From: Laura Gibbons <Laura.Gibbons@arun.gov.uk>
Sent: 24 November 2020 10:31
To: Planning.Responses <Planning.Responses@arun.gov.uk>
Cc: Michael Eastham <Michael.Eastham@arun.gov.uk>
Subject: Y/113/20/DOC- Land South of Ford lane/East of north End Road Yapton

Drainage Engineers Comments Regarding Condition 11

We do not recommend discharge of this condition at this time.

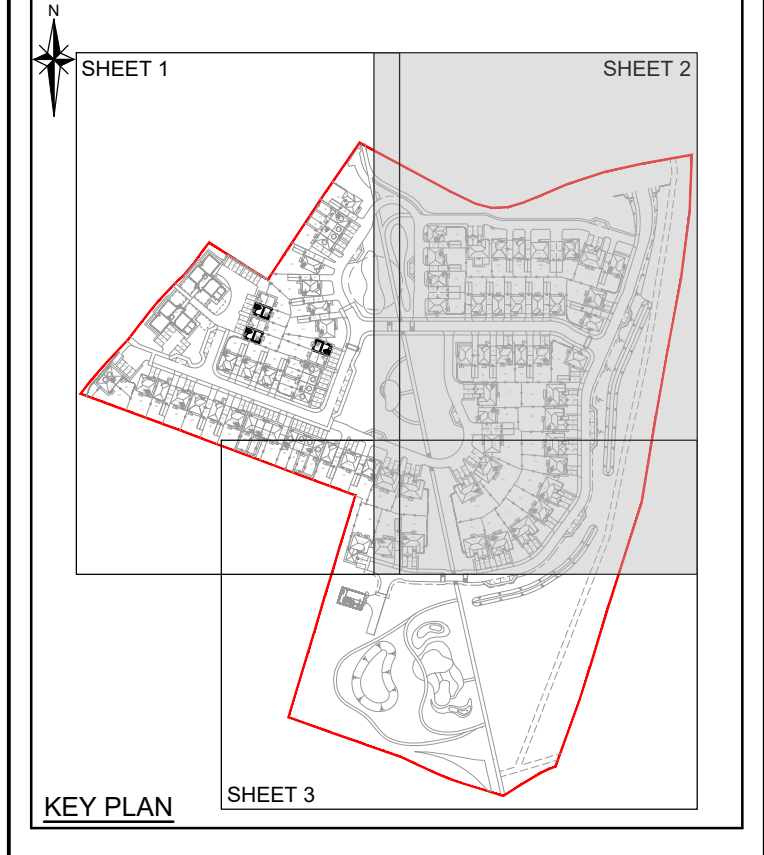
It should also be noted that layout drawings must clearly show finish and formation level of proposed permeable paving, and invert and cover level of all other surface water drainage features.
